KITTTITAS COUNTY COMMUNITY DEVELOPMENT SERVICES

Subject: Williams Shoreline Substantial Development Permit (SD-18-00001)

DRIVEWAY AND BRIDGE SITE PLAN
DRAWING 10

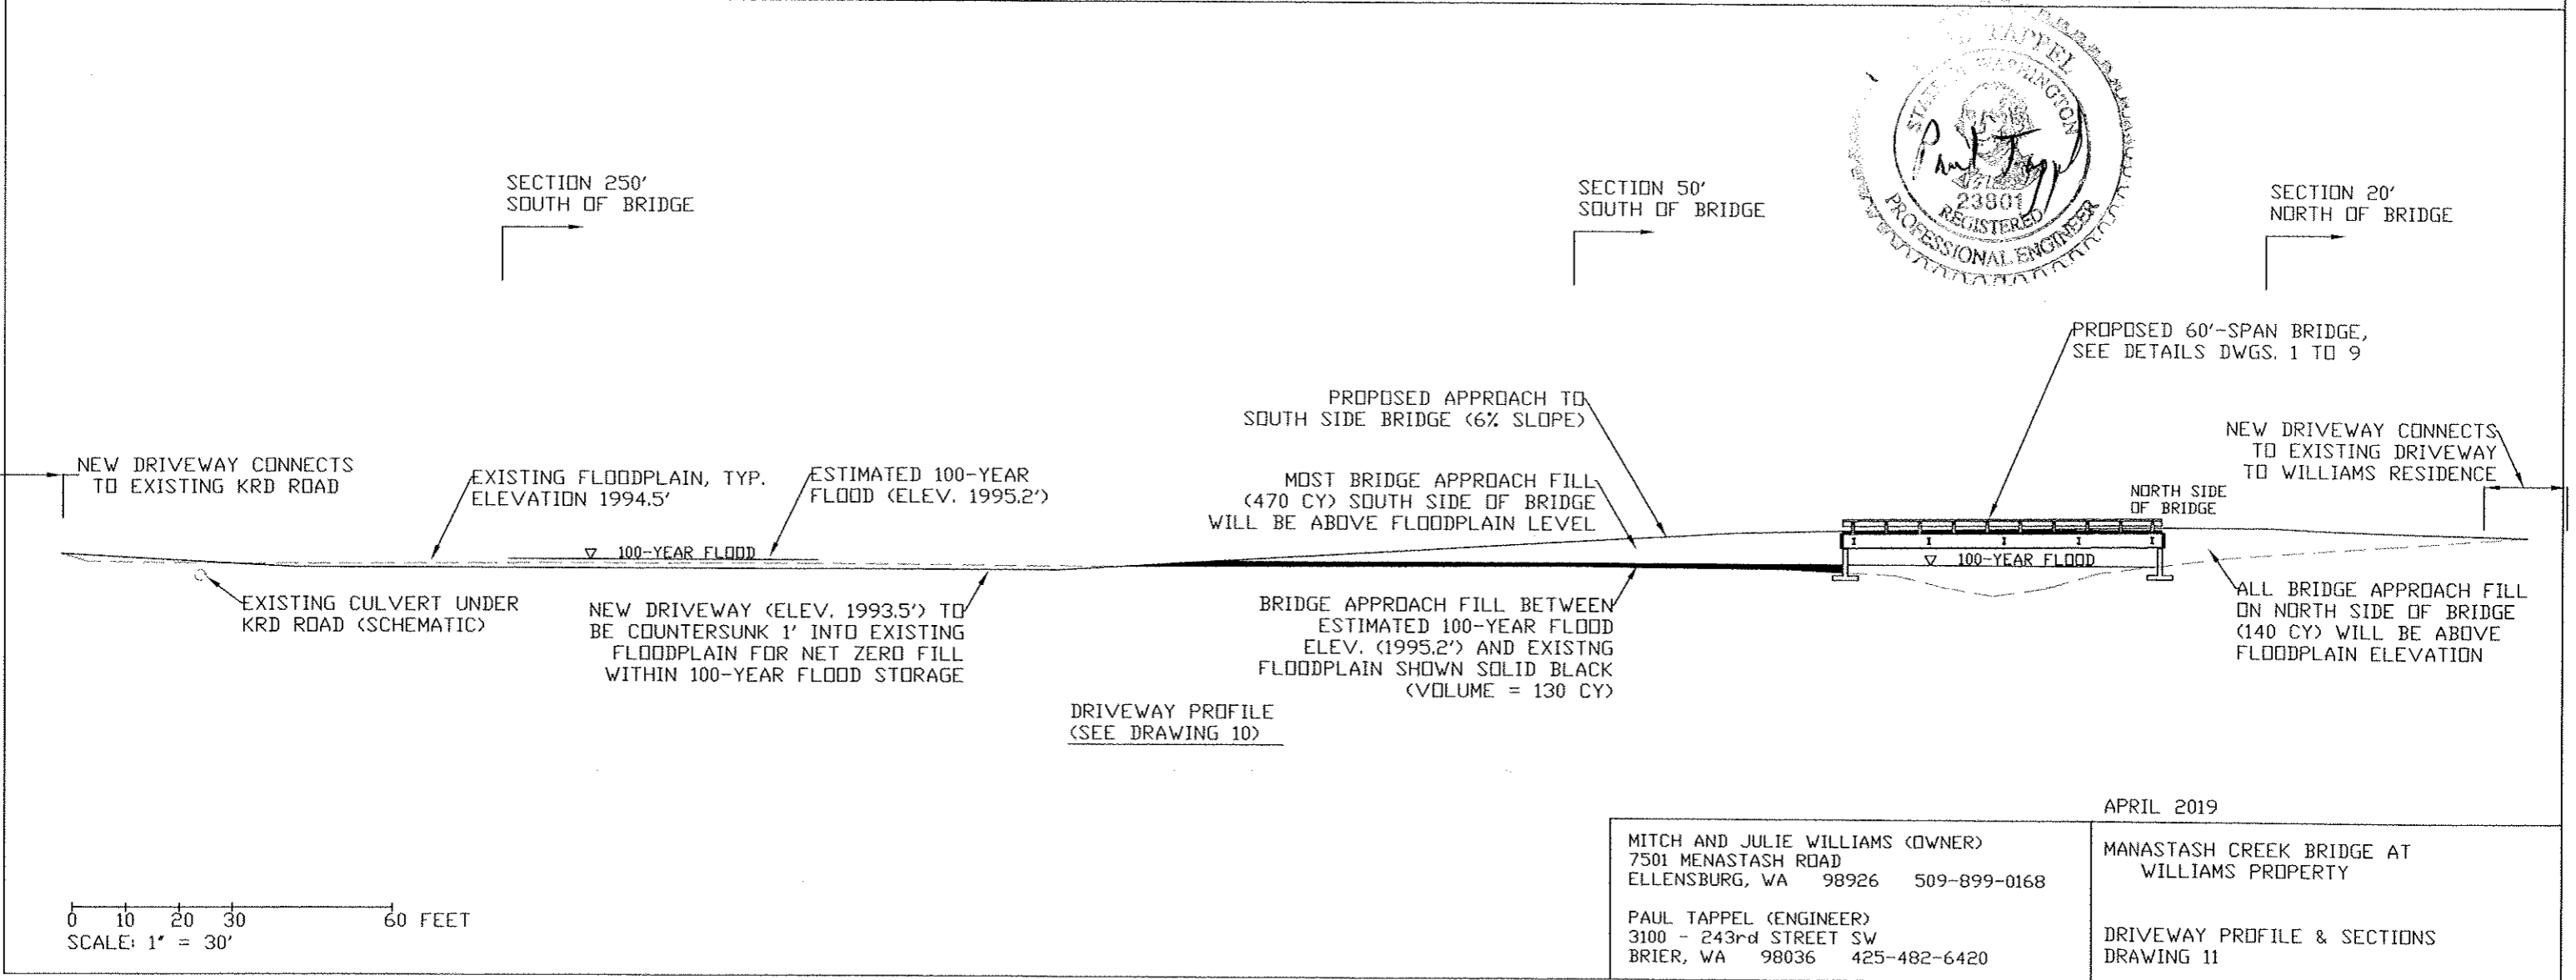
On April 18, 2019 Kittitas County Community Development received the findings of fact and decision for the Road Variance RV-19-00003. Through these findings it was determined that the new driveway and the proposed bridge must maintain the required 16' width. As the original submittal packet only identified a 14' bridge and driveway, we will need updated documents explaining the change. CDS has on file an updated site plan but still requires an updated project narrative. Please provide the requested information by November 21, 2019. Once this document is received CDS can continue with the processing of your application.
